16 March 2013

Re: Council Submission by Pitt St Resident

Objections to Environmental Assessment for a Project Application at the Former Rachel Forster Hospital Site, 134-144 Pitt St, Redfern (MP09_0068)

Figure 86: Photomontages of the subject site (as viewed from Pitt Street)

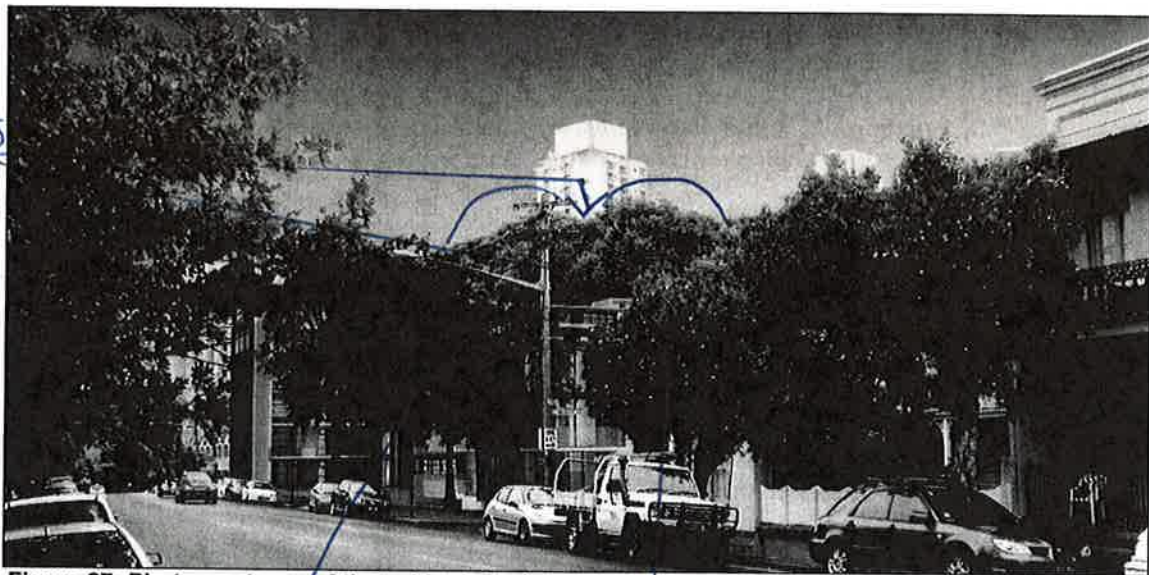
At the town meeting held prior to this proposal being submitted, some resident complaints were raised by local area architects about the quality and sustainability of the materials being used in the new build. I can't see any changes visible in this new proposal, I cannot find information in the submission about sustainable materials, and it is difficult to even guess at the materials being used in the photomontages because of the digital greenery obscuring them. Without mature plantings and mature trees, this development would look very different and it would be helpful to be able to assess the materials in light of more information.

The primary photomontage in the current proposal pictures Pitt Street as a 4 lane artery road and appears misleading in terms of scale and bulk of buildings as they would appear in reality on this suburban street. There is also no view from Pitt Street looking down Albert Street to gauge the effect of the development on Albert St residents.

***ACTION SOUGHT:** photomontages without trees to assess quality of materials chosen; more detail on sustainability/passive thermal control of selected materials to reduce need for air conditioning units, energy waste.*

***ACTION SOUGHT:** 2 new photomontages – primary photomontage with more realistic streetscape width/context and Albert St view West.*
